2024/0633

Site: 11 Wellthorne Lane, Ingbirchworth, Sheffield, S36 7GJ

Proposal: Single storey side and rear wrap around extension to dwelling

DRAWN BY :	MB	APPROVED BY :	MB
DATE :	15/07/24	DATE :	15/07/24
SCALE :	As Shown	ORIGINAL DRAWING SIZE	841 x 594 - A1
DRAWING No	WLI-(PL)-002	REV.	/

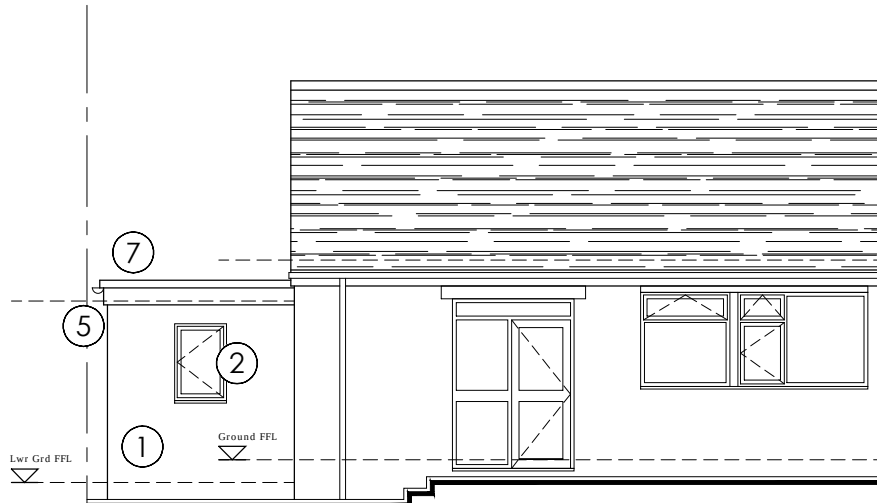
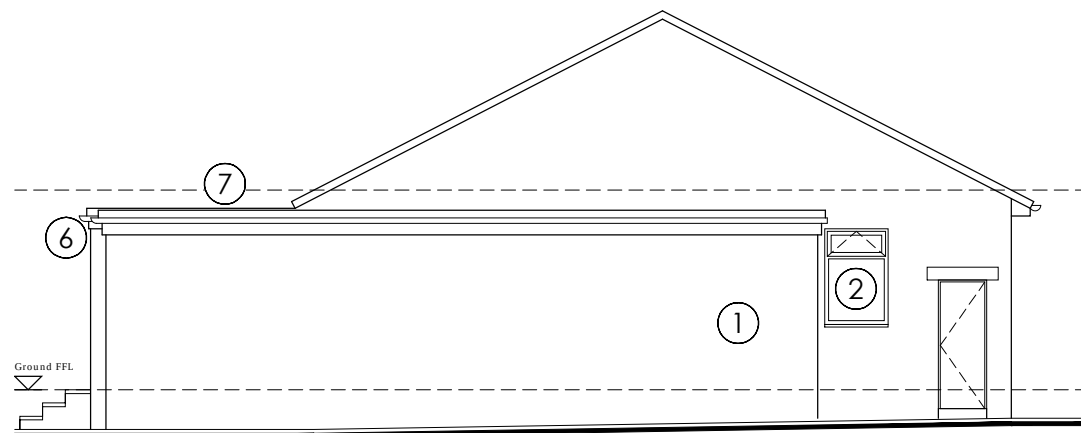
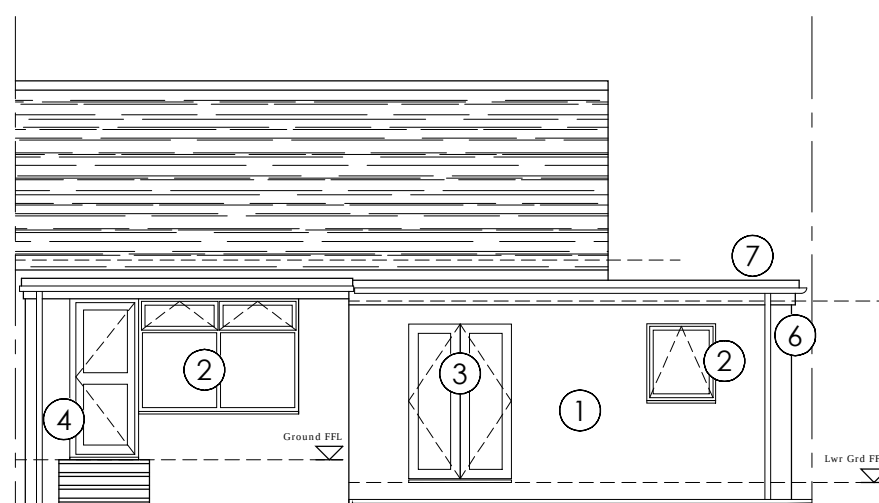
The extension has been amended and now utilises a shallow lean- to roof design to the side elevation to match the existing dwellinghouse, contact was made with the applicant to amend the plans during the consideration of the application as the proposals were originally submitted with a flat roof design which would have appeared contrived and was not in keeping with the surrounding character. Since the changes have been made, the redesign is akin to the existing roof design and therefore is acceptable. A hipped element is included to the rear elevation of the extension.

The applicant had amended the plans after contact was made regarding the design of the roof, this was amended to look less contrived and be in keeping with the LPA's policies.
